**District:** Cherwell

**Application No:** 20/03630/DISC

**Proposal:** Discharge of Condition 12 (landscaping scheme), 20 (Landscape and Ecology Management Plan (LEMP)), 21 (external lighting) and 22 (electrical vehicle charging) of 19/01740/HYBRID

**Location:** Land Adj To Promised Land Farm, Wendlebury Road, Chesterton

Drawing Number:
41602(62)101

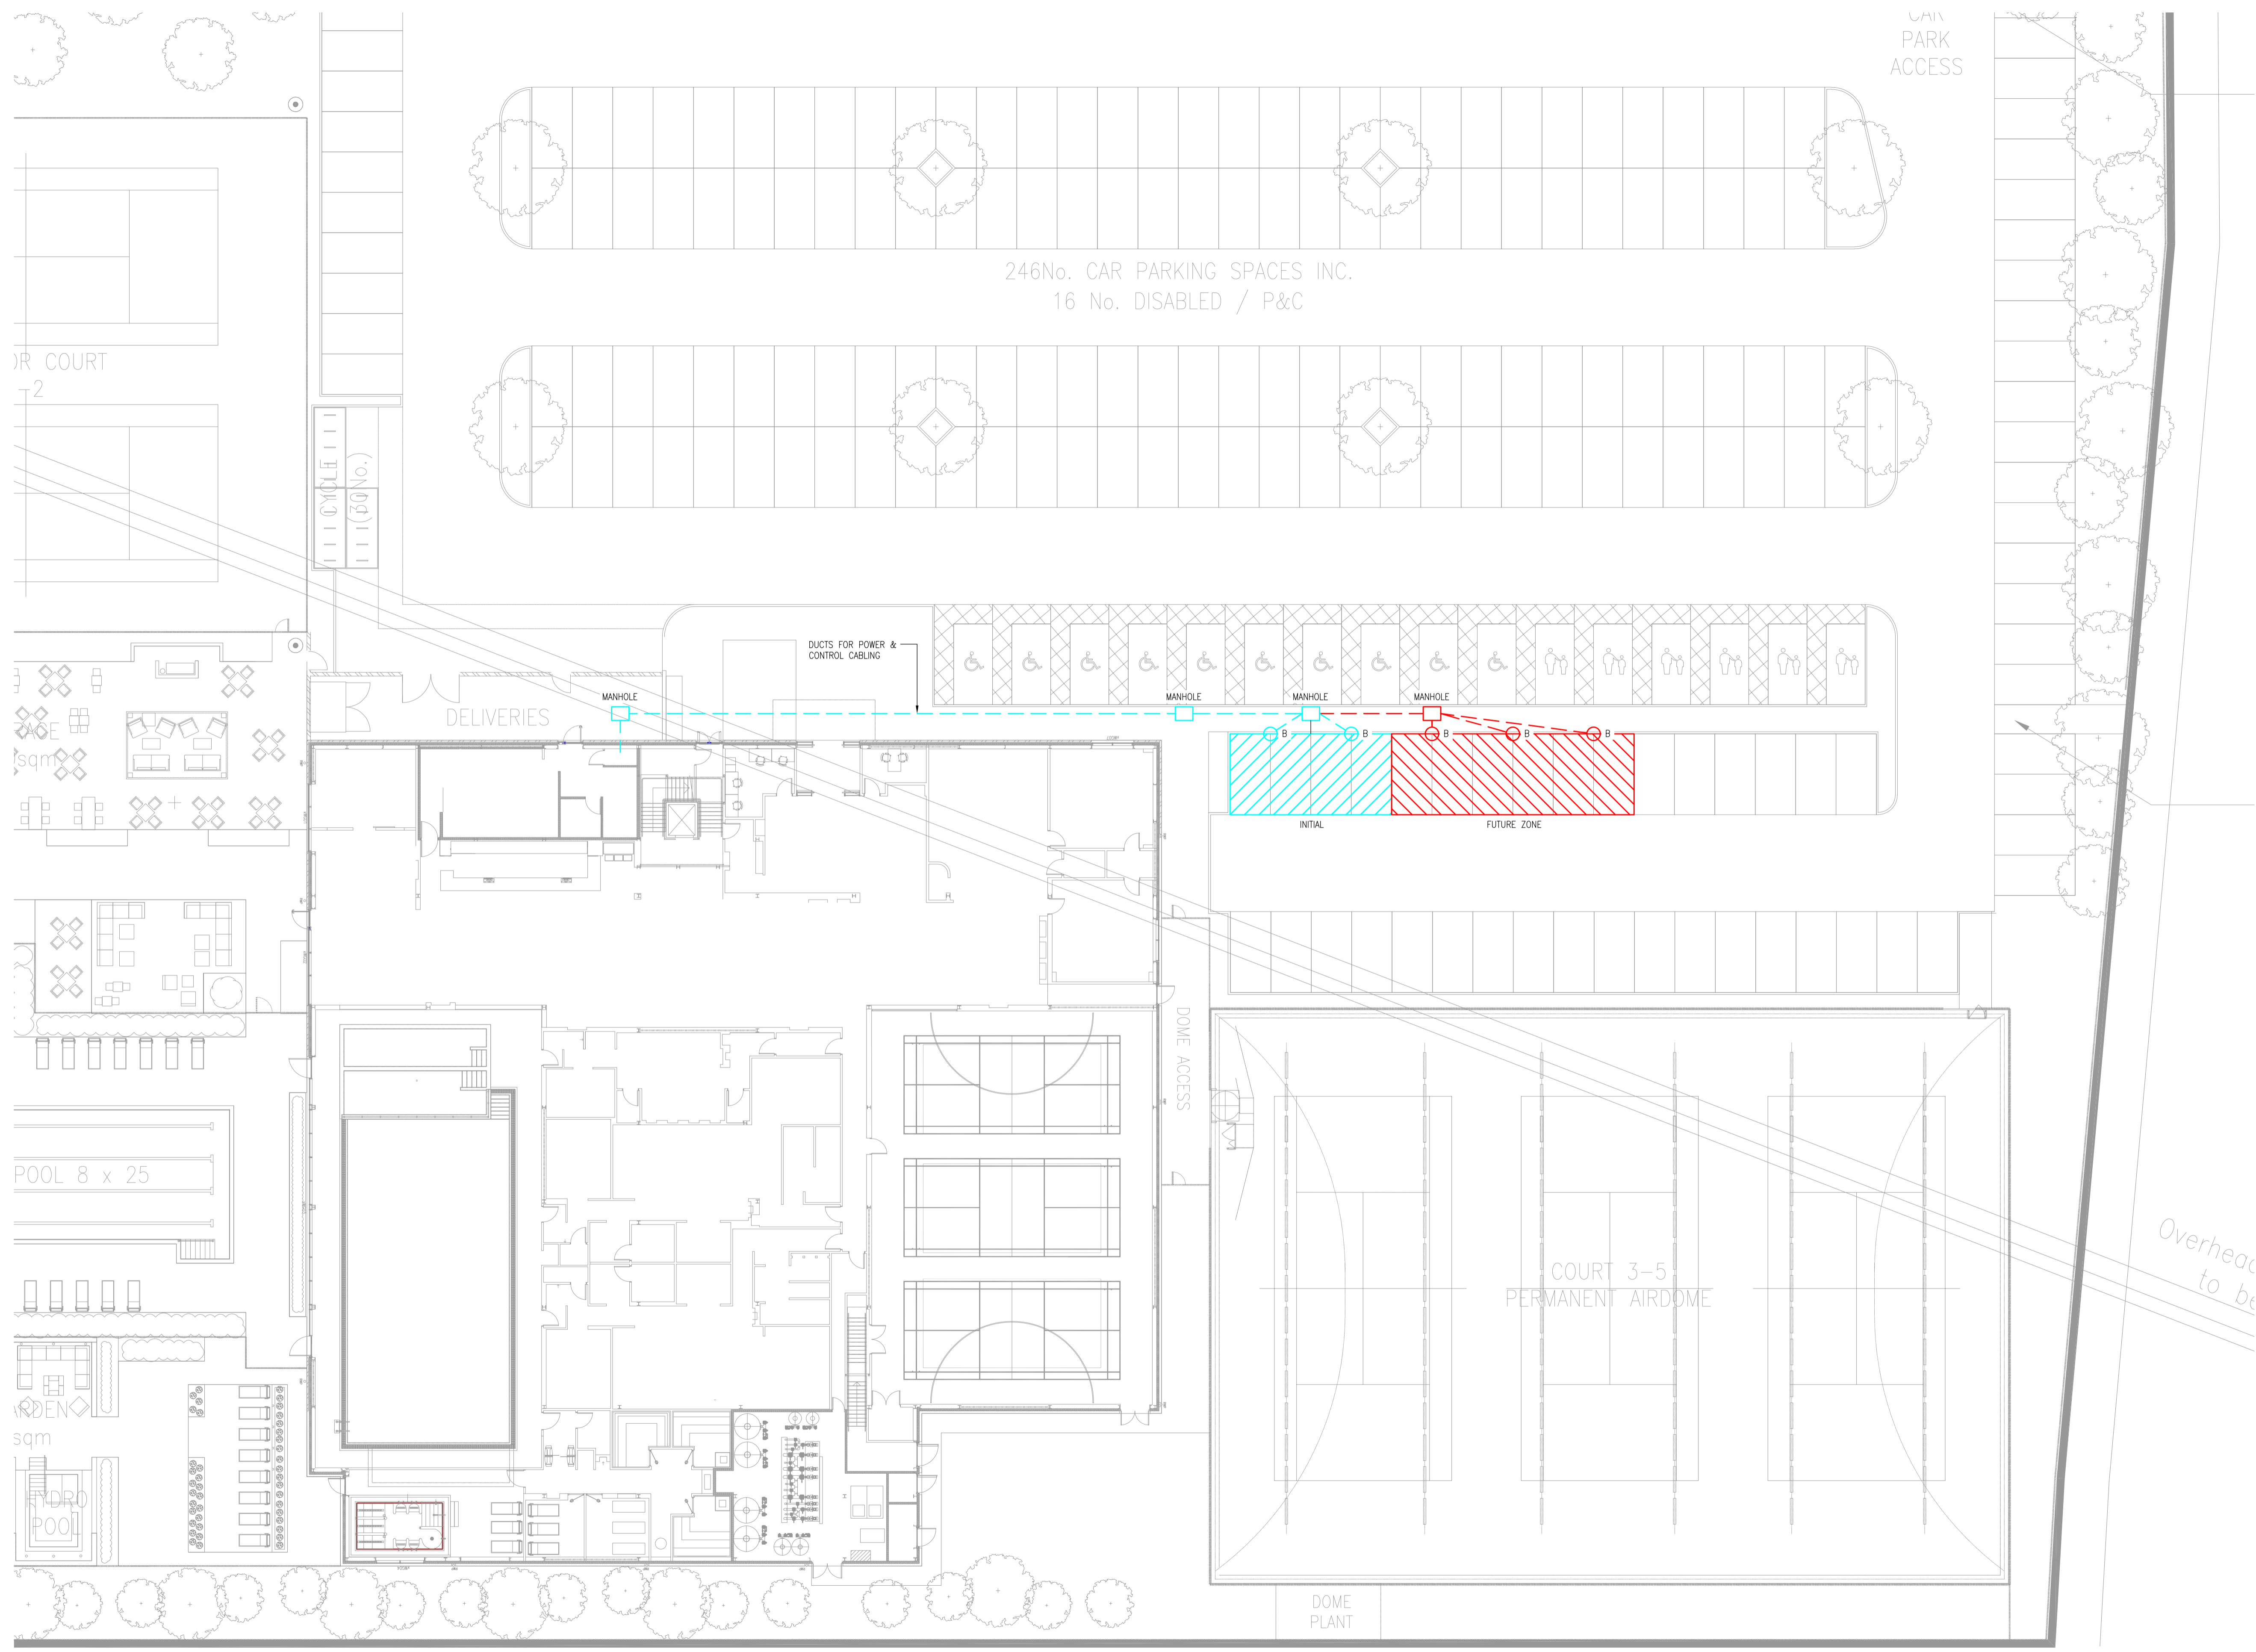
The electrical car charging units provided and/or the ducting for future expansion are inadequate to meet the requirements of the condition.

EV charging has been provided to only 4 parking spaces. Although no amount was specified, it is my view that more needs to be provided (at least about 5%) with the rest of the provision (or at least 20%) to be ducted for future expansion.
